Howes Lane/Bucknell Road/Lords Lane

Technical Review

Document Reference: 1000003465/TN/NB/01

Date: 20th December 2016

title
**HOWES LANE / BUCKNELL ROAD + LORDS
 LANE / BUCKNELL ROAD JUNCTIONS
 TRACKING FOR 12m SINGLE DECK BUS
 SHEET 1**

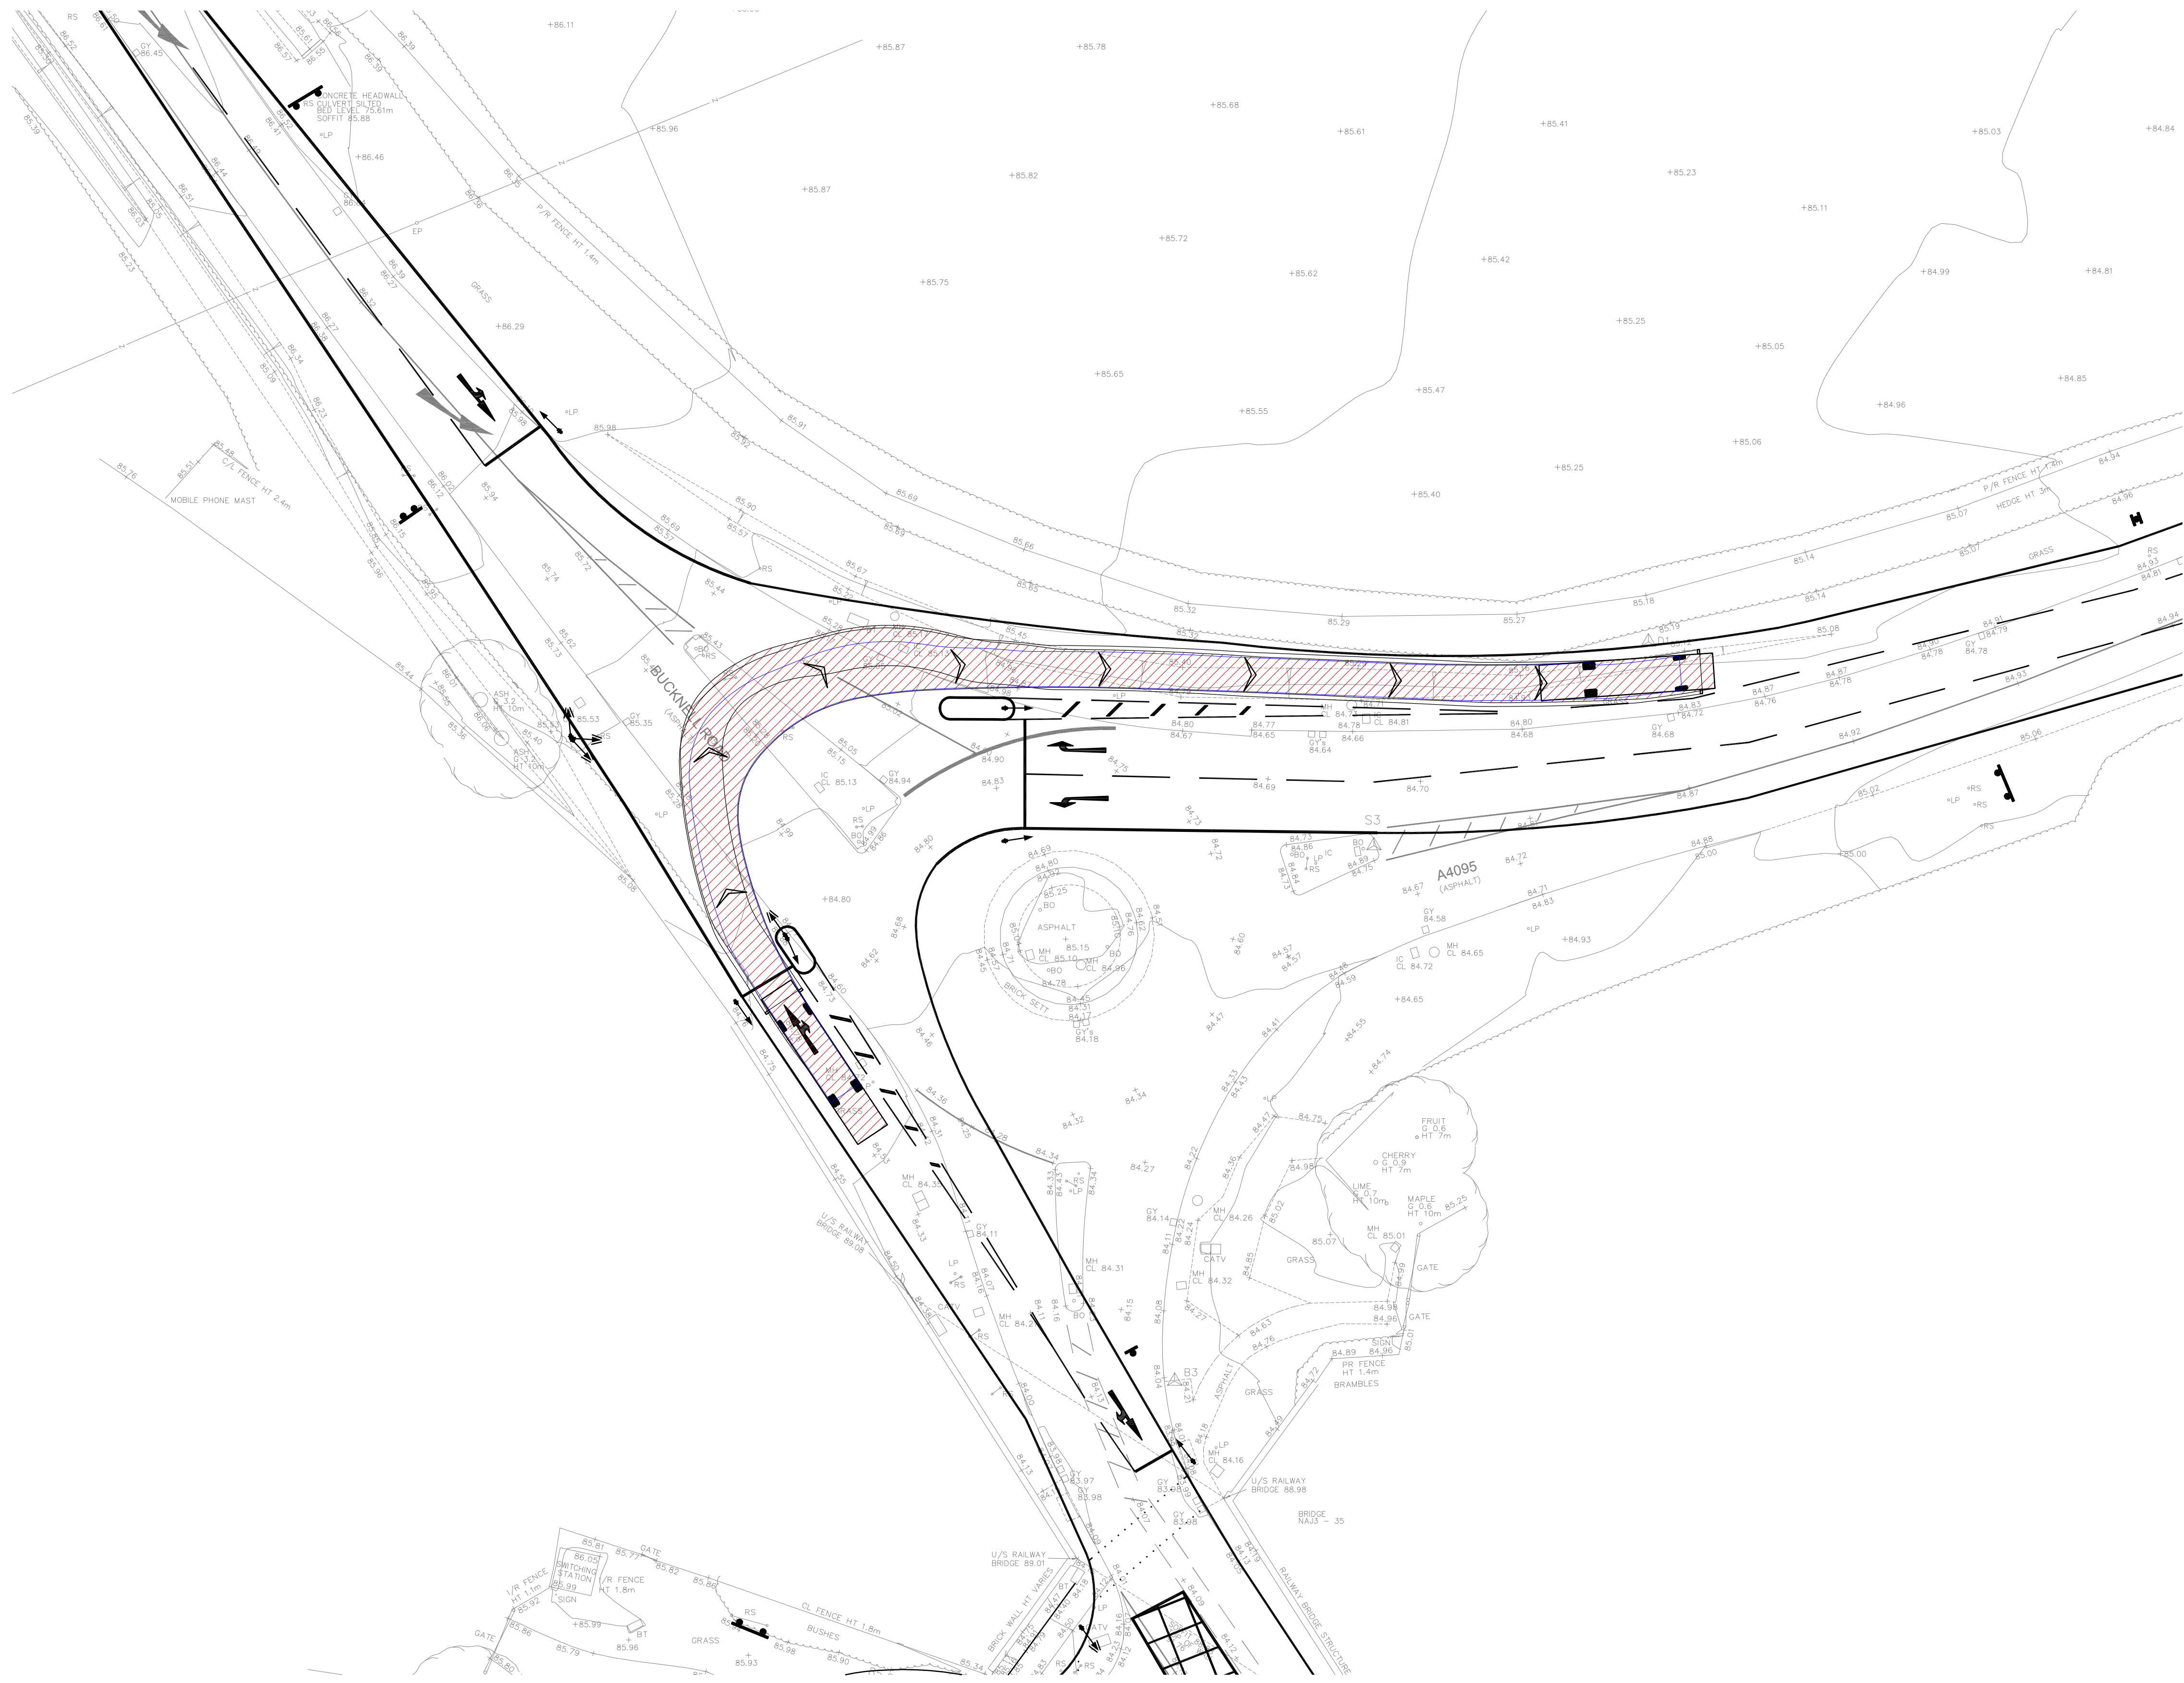
Vehicle Tracking		
<p>Comments dated 1/12/2016</p> <p>There are instances where a tracked vehicle crosses the centre line of the road or is very close to kerb lines.</p> <p>It appears that a vehicle approaching the junction on Howes Lane has to come to a complete stop and then turn its wheels before moving off so that it can negotiate the junction layout. This would interfere with efficient movement of traffic at the junction and dilute the</p>	<p>Response dated 6/12/2016</p> <p>There is still scope and space within the limits of the public highway for further refinement of the layout to address these issues.</p> <p>Nonetheless, it must be noted that these situations would only arise with the very largest of vehicles and would only be an issue if an equally large vehicle were to be travelling in an adjacent or opposing traffic lane. In reality, because of the</p>	<p>Existing Situation</p> <p>Site observation indicate that current vehicle movements, particularly for HGVs include:</p> <ul style="list-style-type: none"> • Left turn out of Howes Lane crossing over the centre line into the opposing lane • Right turning vehicles into Howes Lane turning into the oncoming right turn lane out of Howes Lane • High speed right turning movements into Howes Lane to get across the junction in small gaps when drivers become frustrated in queuing traffic

<p>capacity benefits that the scheme may offer.</p> <p>Where drivers do not negotiate the junction perfectly, it would result in damage to infrastructure.</p> <p>Should a vehicle with any kind of overhanging load try to use this junction then there could be concerns for pedestrian safety and possibly damage to centre islands / signal equipment or even the Bucknell Road bridge itself, where a section of footway has been removed altogether and the carriageway moved to 700mm from the bridge abutment.</p> <p>At this point there is uncertainty over whether Network Rail would give permission for the kerb line to be so close to the bridge structure, because of the risk of damage.</p> <p>Comments dated 6/12/2016</p> <p>OCC agree the introduction of refuges would provide some benefit to pedestrians, although as they are narrow, they do introduce the risk of overhanging vehicle bodies clipping pedestrians with bikes or prams due to the tight tracking.</p>	<p>natural mix of vehicle types there would be sufficient clearance.</p> <p>All manoeuvres are on the basis of a vehicle moving while turning its wheels.</p> <p>Vehicle containment kerbs can be used to mitigate risk of collisions with the infrastructure and bridge structure.</p> <p>The proximity of the kerb line to the bridge will need to be confirmed with Network Rail; however the risk of loss of control collisions is predicted to be reduced as a result of reduced speeds at the junction.</p>	<ul style="list-style-type: none"> Left turns into Howes Lane coming into conflict with right turn movements into Howes Lane. <p>All movements were seen to result in heavy and sudden braking. These conflicts occur on a regular basis and predicted increases in traffic flows will increase the risk of a collision.</p> <p>Projected increase in traffic flows through the junction is likely to result in increased congestion which in turn could result in drivers becoming more impatient and taking increased risks.</p> <p>Proposals</p> <p>The proposals increase the size of the junction, set stop lines away from swept paths and provide control thus reducing conflicts between turning vehicles.</p> <p>Observations and Assessment of Risk</p> <p>ABAs indicate there is scope to refine the designs to accommodate instances where swept paths show vehicles crossing the centre line and coming close to the kerb line.</p> <p>It is accepted the combination of low pedestrian flows and low numbers of the largest HGVs means the risk of a conflict occurring is minimal in comparison to existing conflicts at the junction.</p> <p>OCC are concerned about poor driving skills resulting in overhanging of the footway and central refuges. They are also concerned that the central refuges are too narrow, leaving pedestrians vulnerable.</p> <p>The proposals increase the size of the Howes Lane/Bucknell Road junction. Swept path analysis indicates that vehicles including HGVs can safely undertake turning movements through the junction, reducing the risk of a collision with other vehicles This is particularly true of left turn vehicles that currently overrun the south –eastbound lane on Bucknell Road, and right turning vehicles into Howes Lane who overrun the right turn lane out of Howes Lane.</p> <p>The swept path analysis provides a margin of safety and it is felt the risk of vehicles overhanging the footways and striking highway infrastructure is low.</p> <p>The design of the central refuge is in accordance with current guidance. They provide a safe place for pedestrians to wait and therefore are an improvement on the current situation where</p>

<p>pedestrians must cross three lanes of traffic with no refuge.</p> <p>Whilst there may always be some risk of HGVs overhanging footways in any highway environment, the swept path analysis shows that they can safely undertake the turn without overhanging the footway at this location.</p> <p>The conflicts described above indicate that there are existing risks of collision occurring with the current layout which the proposed design removes or reduces.</p> <p>The issue of the bridge needs to be considered in liaison with Network Rail; however the provision of the containment kerbs proposed by ABA will provide greater protection to the bridge and pedestrians.</p>
--	--	----------------------------------------------------------------------------------------------------------------------------------------------------------------------------------------------------------------------------------------------------------------------------------------------------------------------------------------------------------------------------------------------------------------------------------------------------------------------------------------------------------------------------------------------------------------------------------------------------------------------------------------------------------------------------------------------
